**RE: Heritage Marketplace Tract A2 (Burger King)
7900 Ladera Dr NW
Grading and Drainage Plan
Engineer's Stamp Date 12/19/17 (File: H09D024A)**

Based on the information provided in your submittal received 12/19/17, the Grading and Drainage Plan cannot be approved for Building Permit. This development is site plan controlled and will require an approved conceptual grading and drainage plan and DRB approval of the site development plan. In anticipation of DRB action, the following will be required:

<div>ENGINEER'S SEAL</div> <div></div> <div>12-27-17</div> <div>Richard Dourte P.E. #10854</div>	Title: BURGER KING 7900 LADERA DRIVE NW	DRAWN BY DATE
	DETAILS	<i>CRD/ang</i>
	<i>R.H.D Engineering, LLC</i> 4305 Purple Sage Ave. NW ALBUQUERQUE, NM 87120 (505) 288-1621	SHEET # 2 of 2
		JOB # XXXX

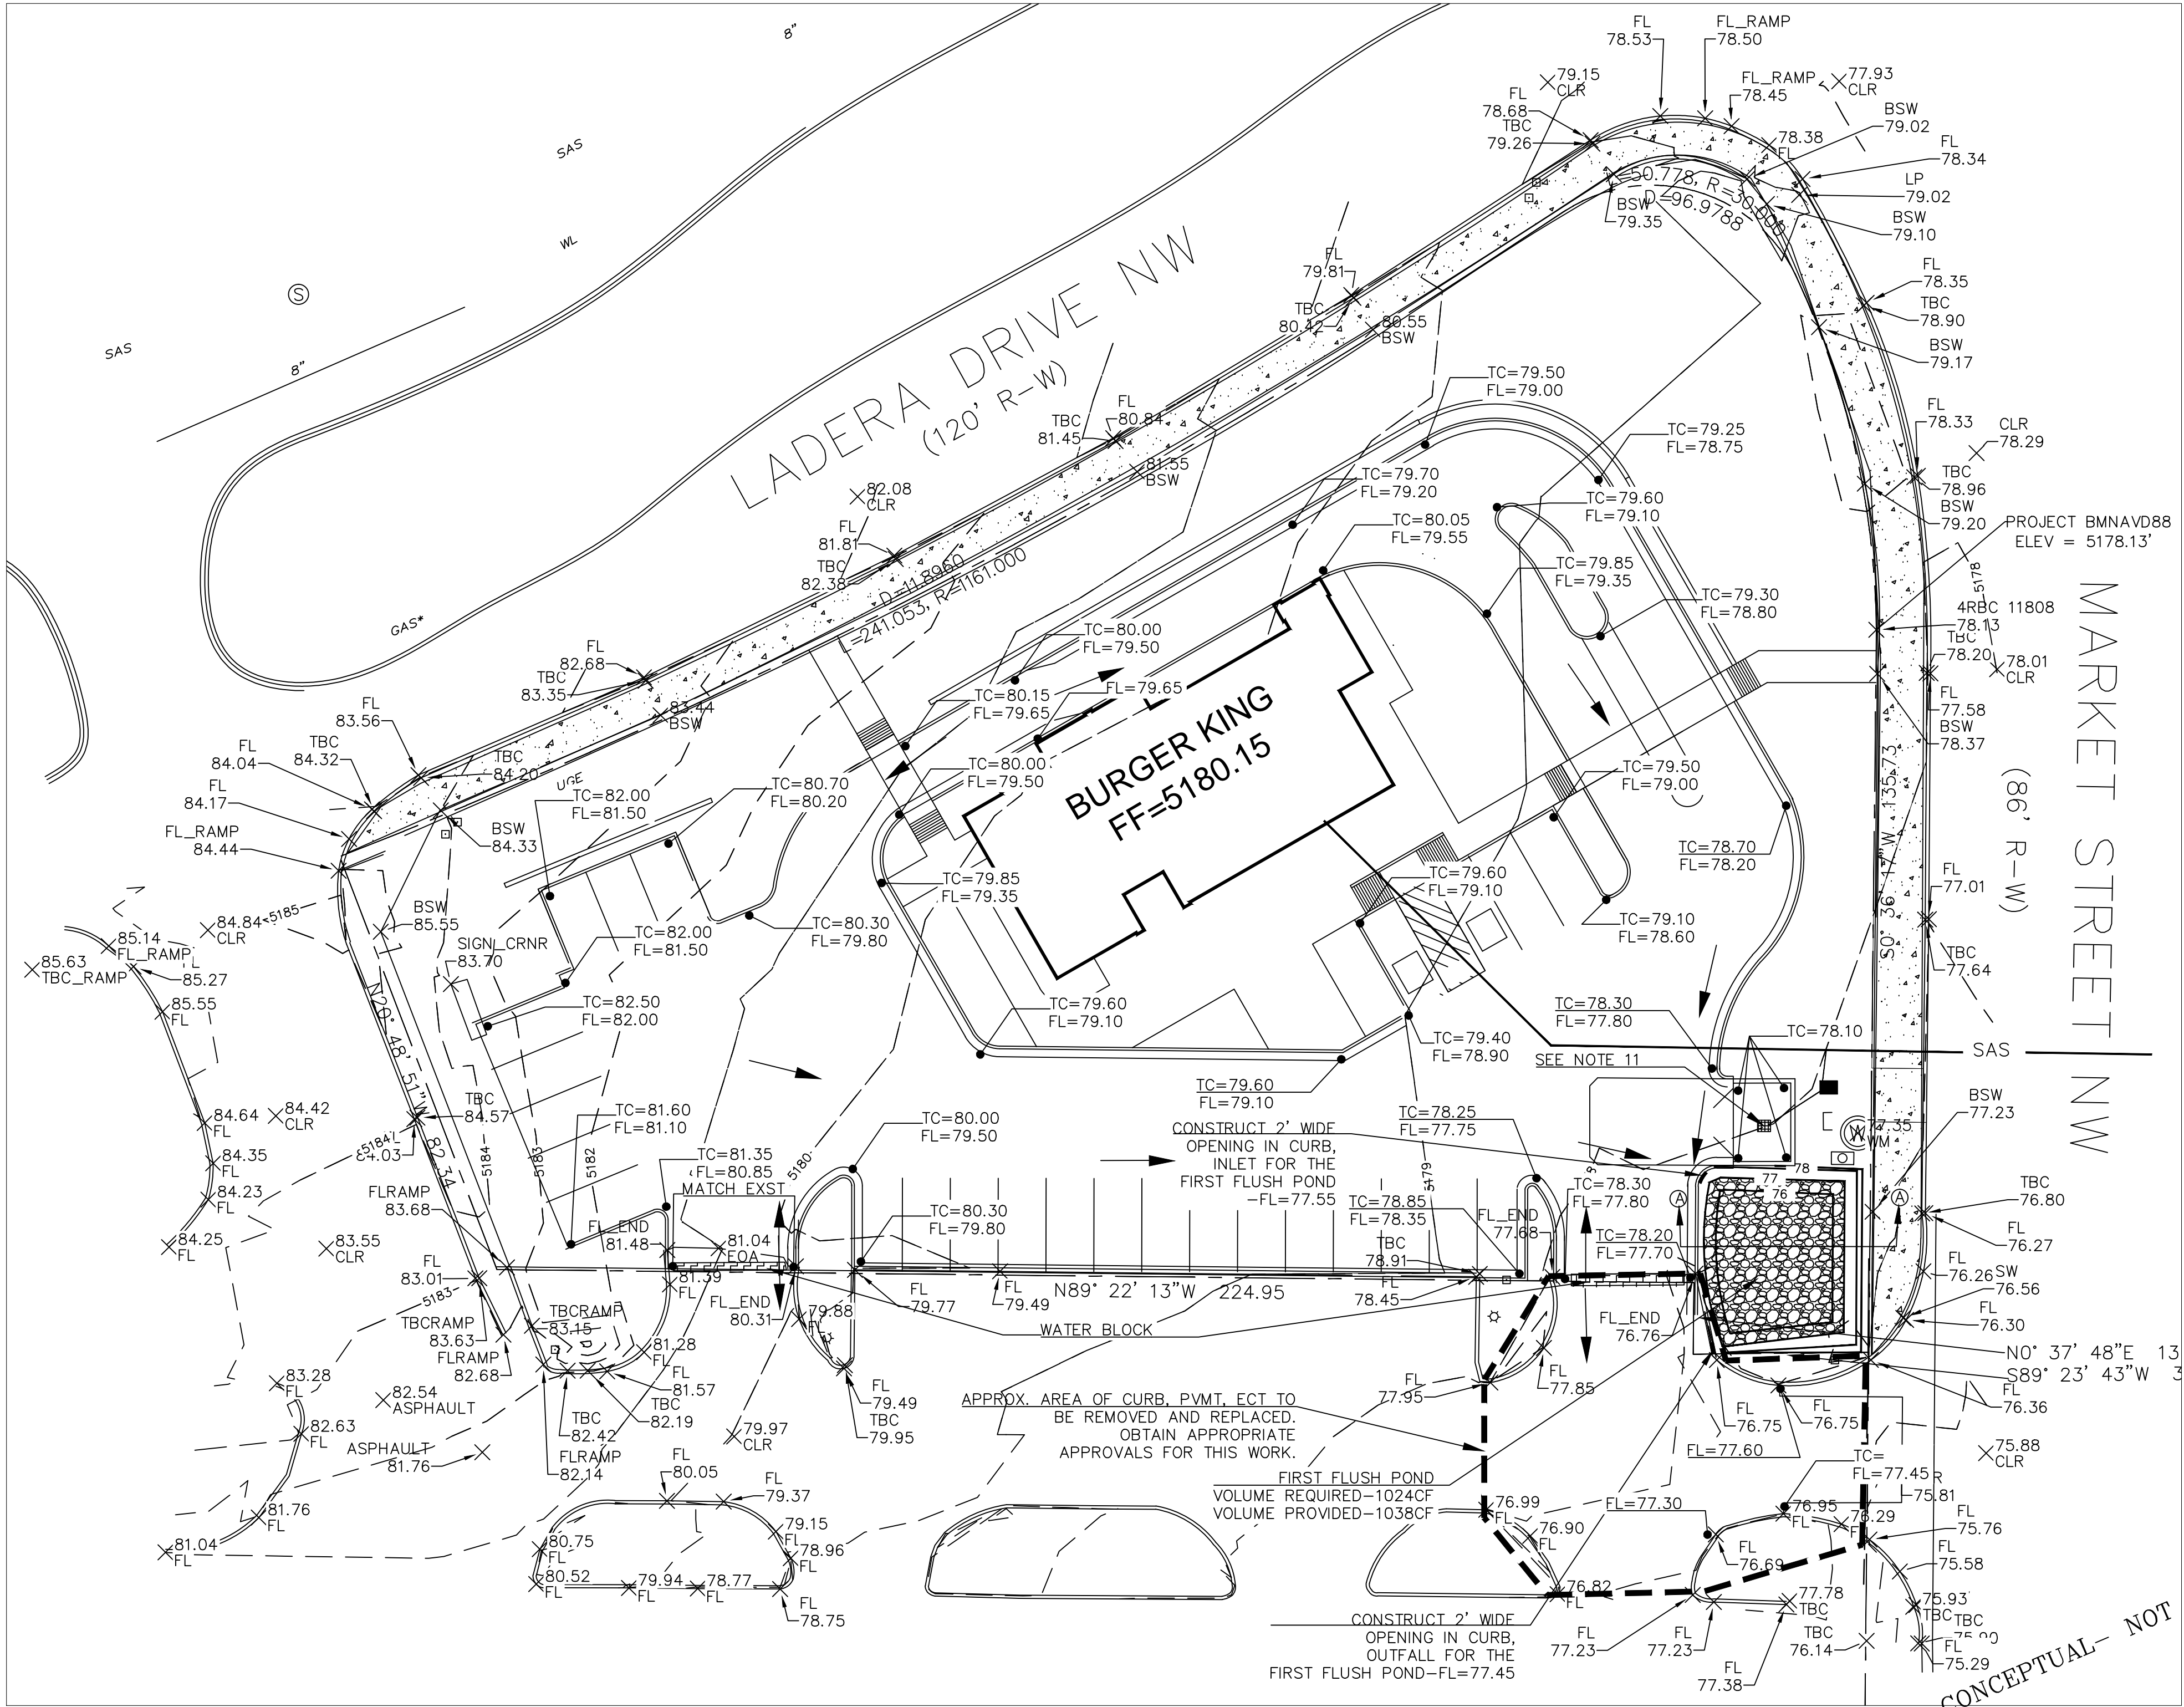
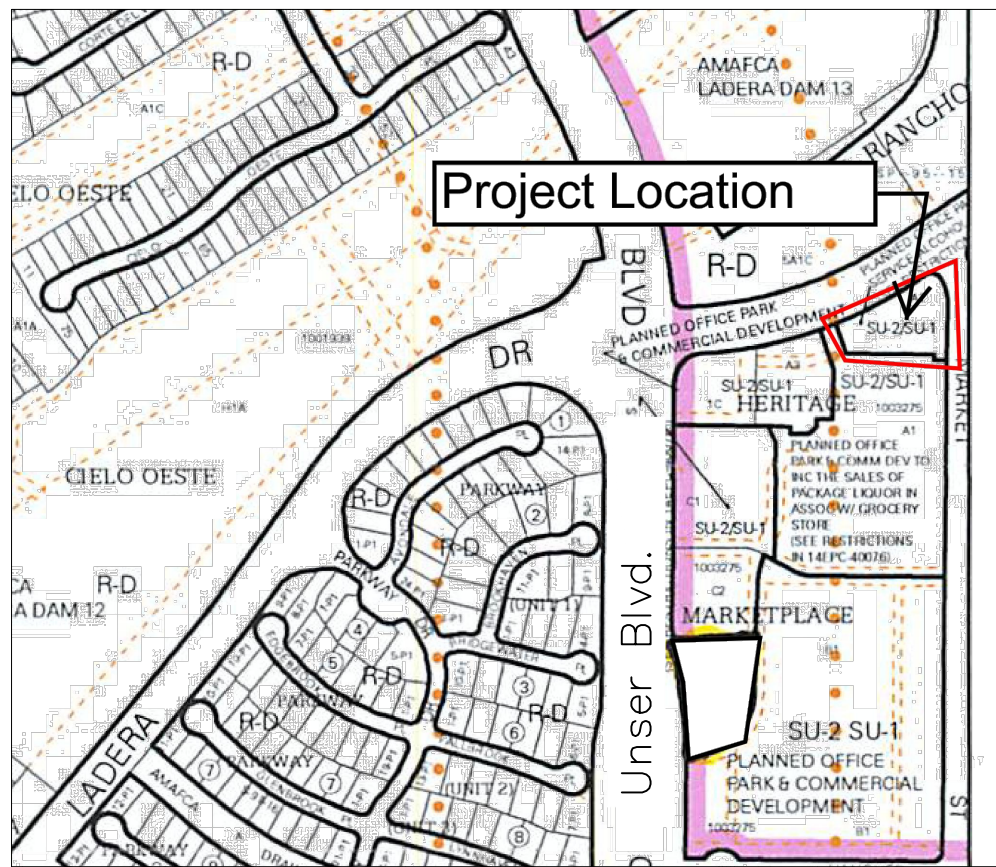
1. The Grading and Drainage Plan will need to be clearly labeled as "Conceptual, not for construction" for inclusion in the Site Plan.
2. Include a narrative describing how this plan of development is in compliance with the approved Heritage Marketplace Drainage Report (H09D024).
3. The dumpster area should be contained, plumbed through a grease trap, and into the sanitary sewer. Include the utility plan if this information is located there. You may also want to raise the dumpster pad elevation to keep storm water from entering the dumpster area.
4. Please provide written permission from the adjoining property (Walmart) for work on their property.

5. A detailed grading and drainage plan, with the "conceptual" markings removed will be required for Building Permit.
6. It is unclear that storm water will be forced into the pond at the curb cut. Please include a clearly defined waterblock at the SE property line/drive entrance that will force flows into the pond instead of allowing them into the Walmart parking lot.
